# **OXFORDSHIRE COUNTY COUNCIL'S RESPONSE TO CONSULTATION ON THE FOLLOWING DEVELOPMENT PROPOSAL**

**Application no:** 14/02121/OUT-3

**Location:** Proposed Himley Village North West Bicester Middleton Stoney Road Bicester Oxfordshire

### **1) OCC response to Himley Village submission of 21 December 2016**

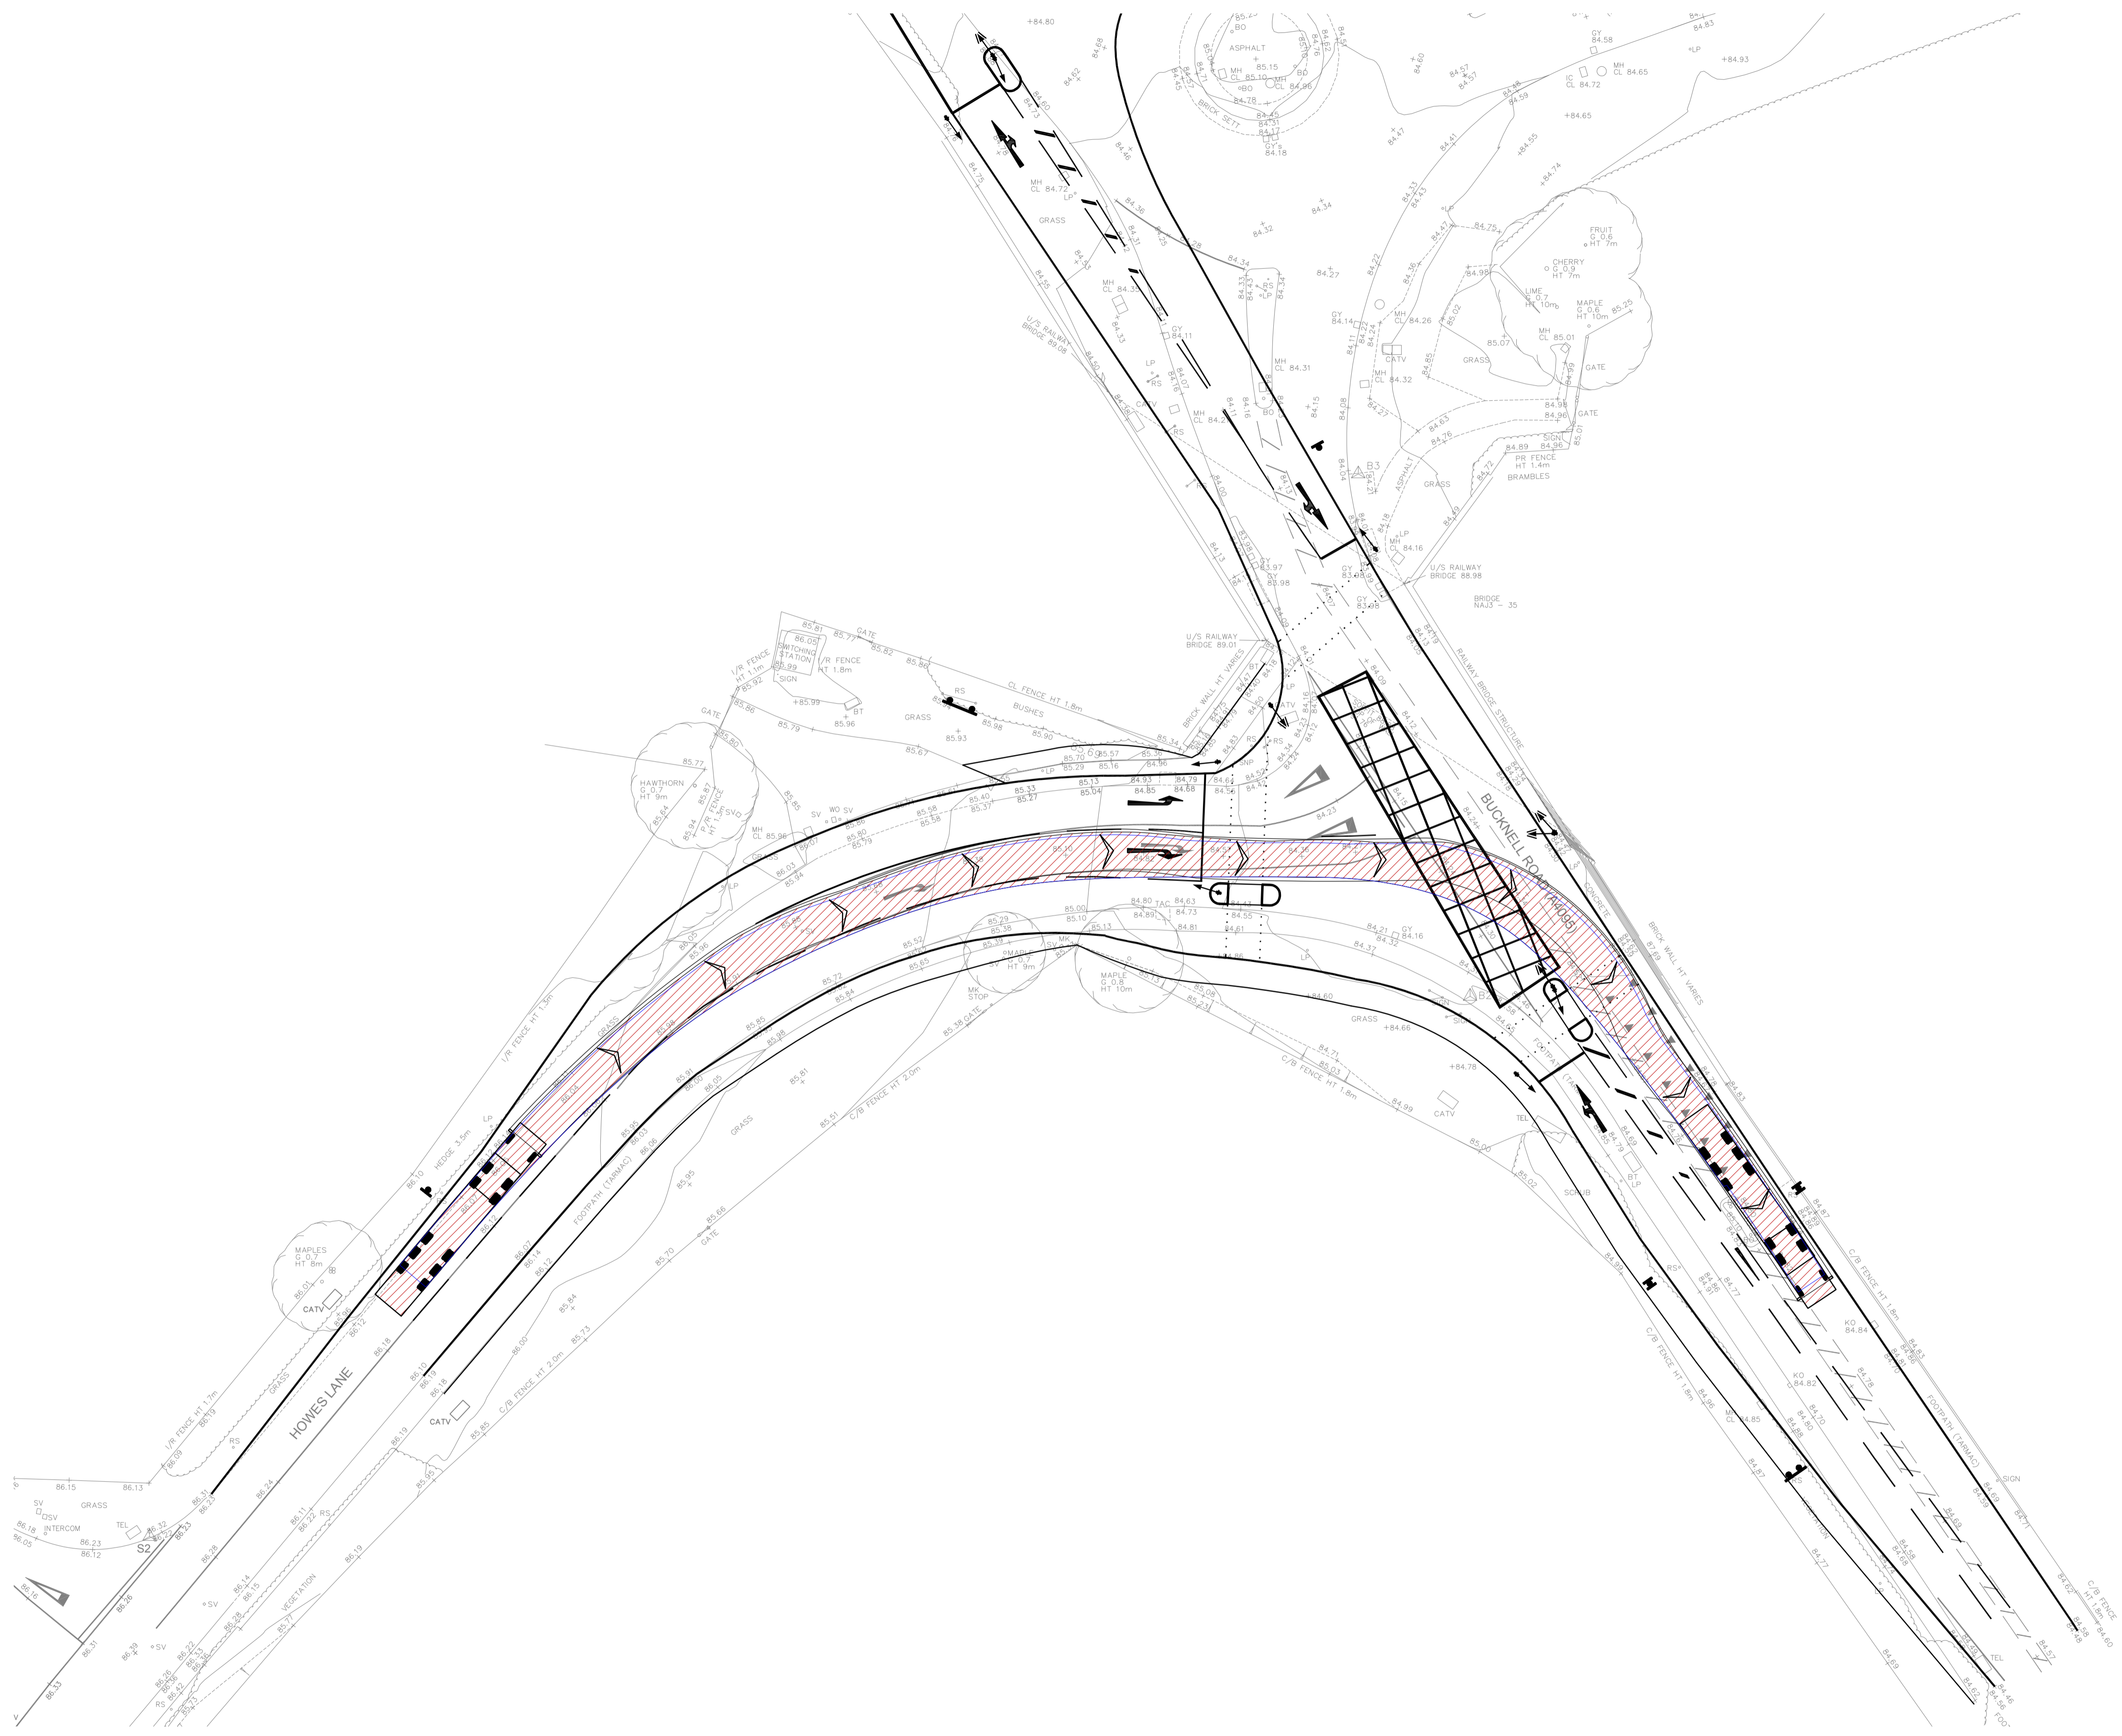
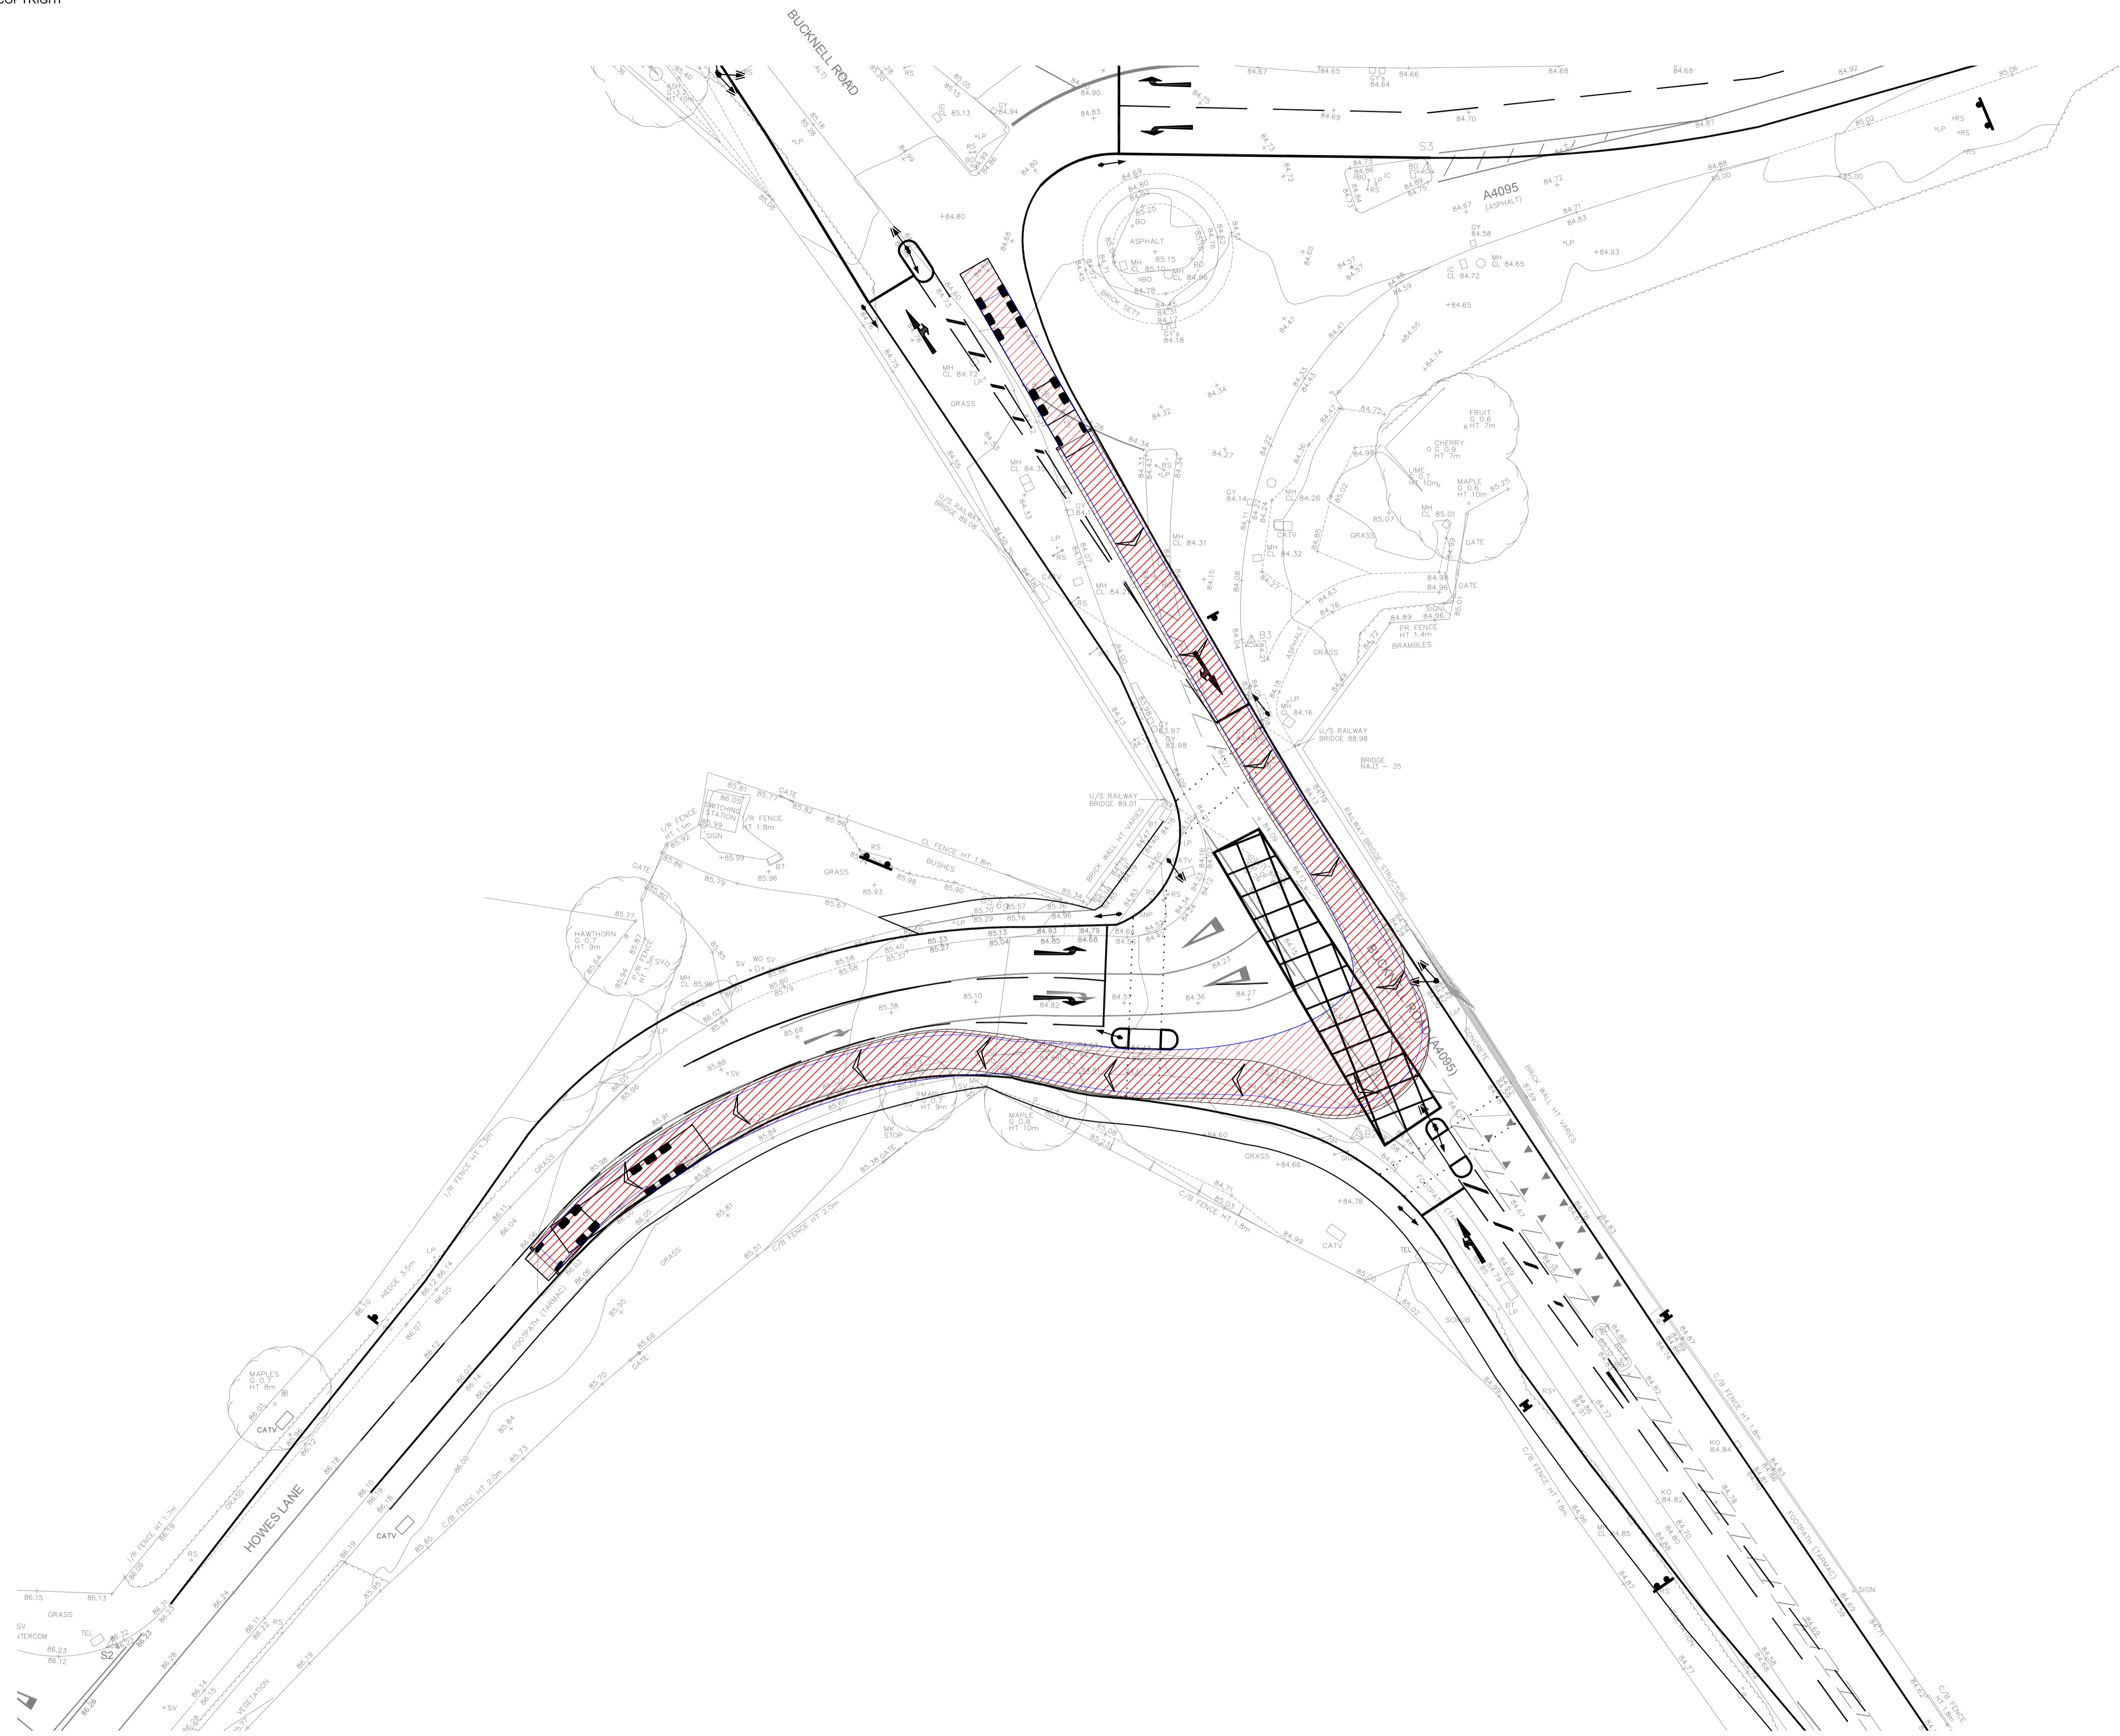
OCC maintains its objection to the proposed interim scheme because the submission does not demonstrate that previously identified problems can be remedied. Rather it states that these issues can be addressed at S278 application stage. The professional opinion of OCC engineers is that space at the junction is so constrained that it will not be possible to address the concerns and produce a design that will satisfy technical and safety audit, and that, as a result the scheme is not feasible. A full critique of the issues raised in the Technical Note is set out in Table 1 below.

Concern raised in OCC response of 15 Dec	Alan Baxter/PCL response to our concern	OCC response
Pinch Point on Howes Lane	<ul style="list-style-type: none"> <li>• Very low usage by pedestrians and cyclists during the hour surveyed therefore can assume low usage throughout the day and therefore very low risk of conflict.</li> <li>• Cyclist use of the footway is illegal anyway and the proposed scheme means they would be less likely to use the footway</li> <li>• Footway widths of no less than 1m at pinchpoints can be confirmed at next iteration of design (S278 application)</li> </ul>	<p>PCL, as part of the safety audit of the existing conditions carried out for Alan Baxter, did a ped/cycle count between 0740 and 0840 on Thurs 15 Dec. 2 peds and 3 cyclists were observed using the footway on the SE corner of the Bucknell Rd/Howes Lane jct.</p> <p>I would argue that this hour is not representative as it would not cover all people walking to work at the employment site and it is also unlikely to be representative of leisure users of the bridleway.</p> <p>In any case, I reiterate that even if pedestrian use is low, this does not remove the risk, either of collisions between peds or peds and cycles, or of peds/cycles being swiped by passing vehicle overhangs.</p>

<ul style="list-style-type: none"> <li>• Vulnerability of pedestrians given proximity to turning HGVs is noted but risk is discounted due to low number of pedestrians. PCL recommends widening footway to overcome this.</li> <li>• Suggestion that adherence to Inclusive Mobility guidelines is not required because people with mobility issues are unlikely to be using the footway here: 'people with mobility issues tend to undertake short journeys with a specific destination'</li> <li>• Footway extension on north side of Howes Lane could remove the problem provided sufficient widths can be maintained around street furniture. Recommendation to extend footway to Police Training Centre</li> <li>• Proposal of an option to look at relocating the central refuge on Howes Lane to provide additional footway width, and to carry out ped/cycle surveys during peak hours and weekends, for 'further development and finalisation of the junction design'</li> </ul>	<p>I also reiterate that, given the knowledge that cyclists use the footway, this must be taken into account. It cannot be concluded that cyclists would be less likely to use the footway in the proposed scheme. The Alan Baxter note says that 'experienced and confident cyclists (who are more likely to be on the carriageway than the footway) will position themselves so that they are close to the middle of the lane with vehicles following behind them' making it '...relatively easy for them to move across to the right hand lane on approach to the signals.' This reinforces my point, because the <u>less</u> confident cyclists are still likely to use the footway, as well as ones trying to avoid the queues. The provision of advanced stop lines would have little benefit as there is insufficient space to provide a lane leading into them, so cyclists would not be able to get to the front of the queue to enter the ASL box.</p> <p>I strongly refute the suggestion that people with mobility issues should not necessarily be catered for in this scheme, for reasons of inclusivity. In any case there is no basis for the suggestion that this kind of user would not wish to use this route.</p> <p>OCC engineers' professional opinion is that space at the junction is so constrained, that sufficient footway widths could not be found at the next iteration of the design, and that the scheme would not be deliverable as it would not pass its technical/safety audit.</p> <p>The footway on the northern side of Howes Lane would be welcomed if there is sufficient space. However, the applicant has not demonstrated that this is feasible. Even though it would make the footway on the south side largely redundant, the</p>

<p>distance from the kerb to the garden fence on the south side could not be reduced further, as sufficient verge is required for maintenance.</p>
<p>Crossing point on Bucknell Rd between Howes Lane and Lords Lane</p>	<ul style="list-style-type: none"> <li>• Proposals provide better visibility between pedestrians waiting to cross and vehicles turning left out of Howes Lane, as well as better awareness of pedestrians under signalisation, in the proposed scheme compared with the current situation.</li> <li>• Signalisation improves the opportunities for crossing safely here, even without a pedestrian phase, and also increases the predictability of vehicle movements, allowing regular users to learn when in the traffic signal phasing, it is safe to cross.</li> <li>• Proposal of an option to consider a pedestrian phase on the assumption that it would not be called every cycle (and therefore may not impact on capacity).</li> </ul>	<p>CPL has carried out a Stage 3 safety audit for Alan Baxter, of the existing arrangements. Please see discussion of that safety audit below as we do not accept its findings and it does not agree with the independent safety audit carried out for the recent mitigation scheme at the junction.</p> <p>The predictability argument is not conclusive, but even if I was prepared to concede this point, we still have significant concerns about this crossing point. The crossing point is at a pinch point where the tactiles would be only 0.7m wide (between the kerb and the bridge abutment wall) at their northern point, and vehicle tracking is extremely close to the kerb.</p> <p>Also, on rechecking the drawings, the intervisibility zone is well below DMRB standard (and here I have to correct my previous comment that the intervisibility was adequate) due to the major obstruction of the bridge wall. Whilst there is intervisibility between the stop line on Howes Lane and the crossing point, DMRB requires intervisibility between points 2.5m back from the stop line extended across the carriageway, which the proposed scheme does not provide for, so it does not meet standards.</p> <p>There is a risk that the change to the kerblines could make it easier for vehicles to take the left turn faster than at present. On a green signal, drivers will not hesitate in order to give way to traffic from the right, and may in fact accelerate up to the traffic signals and take the corner quickly, in order not to miss the</p>

<p>green signal, putting pedestrians at risk. Having less than standard intervisibility due to the bridge wall may well exacerbate this risk.</p> <p>Intervisibility between points behind the stop line is primarily required to cater for instances when traffic signals fail and drivers need to see when it is safe to proceed. The fact that the scheme does not meet the standard could well be a reason that a S278 agreement cannot be reached.</p> <p>In terms of pedestrian safety, pedestrian phases would be welcomed, but would have the potential to reduce the capacity of the junction and would need to be modelled. The assumptions regarding frequency of call only once every 7.5 cycles would need to be tested against surveys with pedestrian demand growthed up in line with traffic growth. This would then need to be demonstrated through updating the LinSig model.</p>
Signal equipment and traffic signs		<p>We are agreed that there are likely to be ways of accommodating signage and traffic signals so as not to create an obstruction on the footways but this would need to be demonstrated.</p>

Vehicle tracking	<ul style="list-style-type: none"> <li>Proposals are an improvement on current situation.</li> <li>There is scope to refine the design 'to accommodate instances where swept paths show vehicles crossing the centre line and coming close to the kerb line'</li> <li>Combination of low ped and HGV use means low risk of</li> </ul>	<p>CPL has carried out a Stage 3 safety audit for Alan Baxter, of the existing arrangements. Please see discussion of that safety audit below as we do not accept its findings and it does not agree with the independent safety audit carried out for the recent mitigation scheme at the junction.</p> <p>OCC engineers' professional opinion is that space at the junction is so constrained, that there is no scope to widen the carriageway to address tracking issues, without reducing the footways unacceptably.</p>

<p>conflict in comparison to existing situation.</p> <ul style="list-style-type: none"> <li>• Design of central refuge is in accordance with current guidance.</li> <li>• Swept path in any case provides a margin of safety.</li> <li>• Containment kerbs may be used to prevent damage to structures.</li> </ul>	<p>I do not understand the statement that the swept path provides a margin of safety. It is based on the actual vehicle widths of the design vehicles including their wing mirrors. The notes on the swept path drawings state:  <i>'The computer programme assumes an 'optimum vehicle' in terms of performance and driver ability and hence additional areas for unrestricted movement may be required.'</i></p> <p>Whilst it is acknowledged that the refuges would be of benefit to pedestrians, they result in very tight tracking which would only be achieved by an 'optimum vehicle', implying that in practice the situation could be worse than shown in the drawings.</p> <p>HGV use of the junction will inevitably increase as a result of construction and development around Bicester. Pedestrian use of the junction will increase in proportion with general traffic growth. This means the frequency of potential conflict will increase.</p> <p>It is acknowledged that the refuges are 1.5m wide and therefore in accordance with current guidance in this respect.</p> <p>The use of containment kerbs as satisfactory to prevent damage to the bridge structure, given that the kerb would move to only 700m from the structure, has not been discussed with Network Rail and there is no certainty that this would be accepted by Network Rail at the approval stage.</p>
